Appeal Decision

Appeal Ref: APP/Z4718/D/25/3371463

52 Woodside Crescent, Batley, West Yorkshire WF17 7DY

- The appeal is made under section 78 of the Town and Country Planning Act 1990 (as amended) against a refusal to grant planning permission.
 - The appeal is made by Mr Muhammad Fayyaz against the decision of Kirklees Council.
 - The application reference is 2025/62/91497/E.
 - The development proposed is a dormer window and raised roof.
-

PROPOSED SIDE ELEVATION

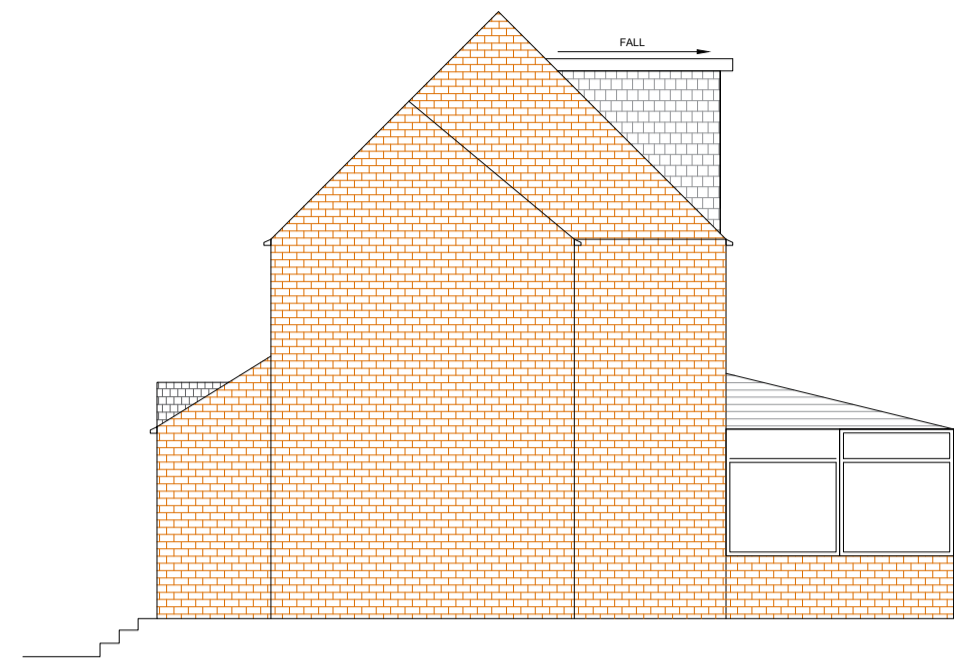
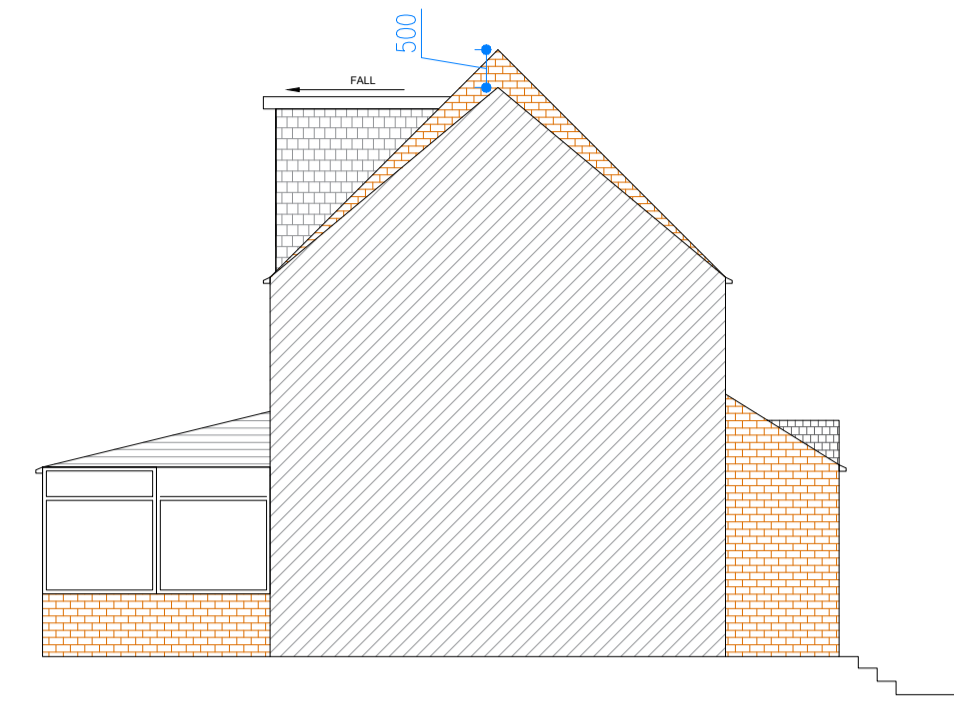
3. The proposal would result in the original roof of this extended end terraced dwelling being raised by half a metre and a dormer window being inserted into the rear roof slope. The council's concern relates to the raising of the roof only.

4. The increased height of the roof would require a steeper pitch. The change in roof pitch and the greater height of the ridge would result in only a very limited change in the relationship between the roof of the existing side extension and the proposed roof. The higher roof would however materially change the relationship with the attached property which currently has a matching roof line. Given that this area of housing is on a hill, there are variations in roof heights across the area. The adjacent terrace includes a step in the eaves and ridge heights to match the slope of the land. The change in ridge height and pitch to accommodate the retained eaves position, as proposed, would differ from the change in levels of the

neighbouring terrace, but not to the extent that it would be a particularly noticeable or prominent alteration.

PROPOSED FRONT ELEVATION

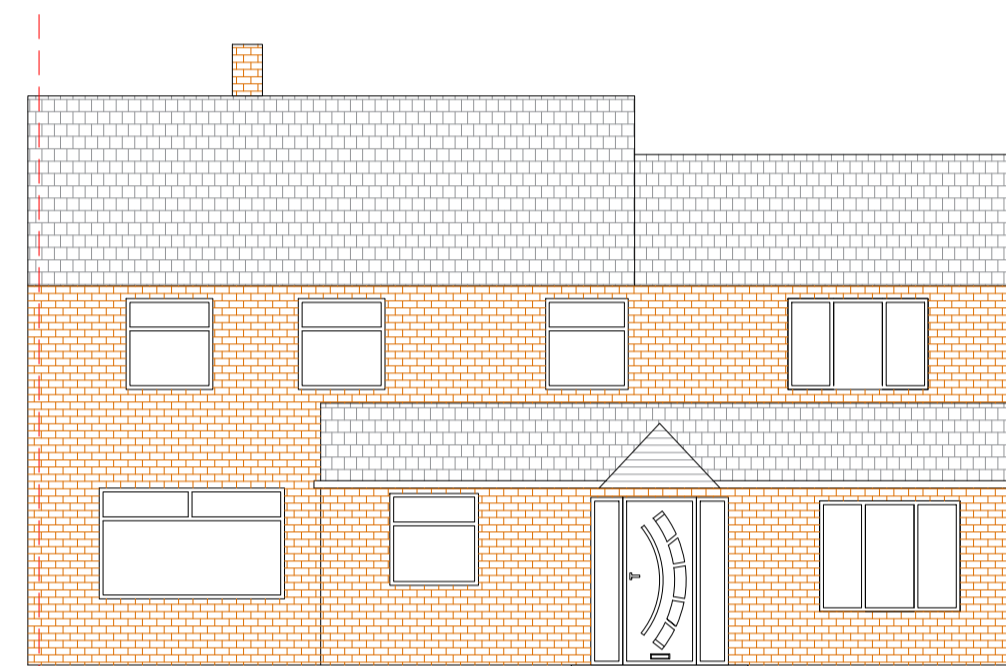
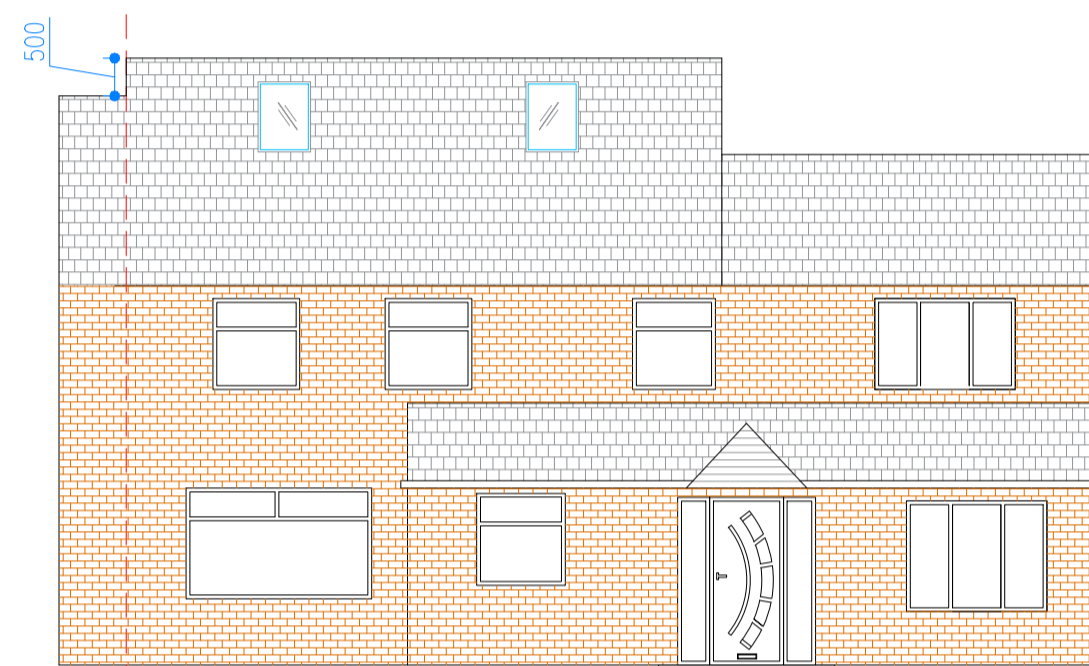
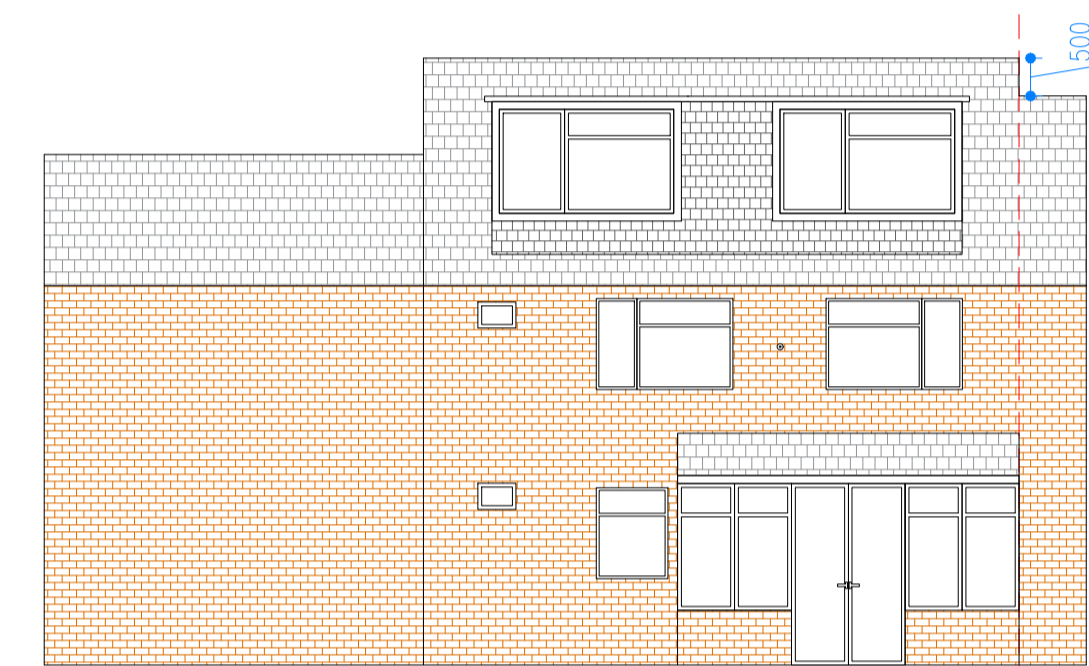
5. Given the limited changes proposed and with the use of matching materials, the proposed works would not result in harm to the overall character or appearance of the area. It would represent a positive investment and achieve additional accommodation without unacceptable consequences for the appearance of the house or the wider area. Although the change in roof pitch would be at odds with the uniform design of these houses, it represents an acceptable solution in these particular circumstances given that it would offer a high standard of amenity for the residents. It would not result in a subservient addition but on balance, it would not result in unacceptable conflict with the design objectives of policy LP24 of the Kirklees Local Plan 2019.
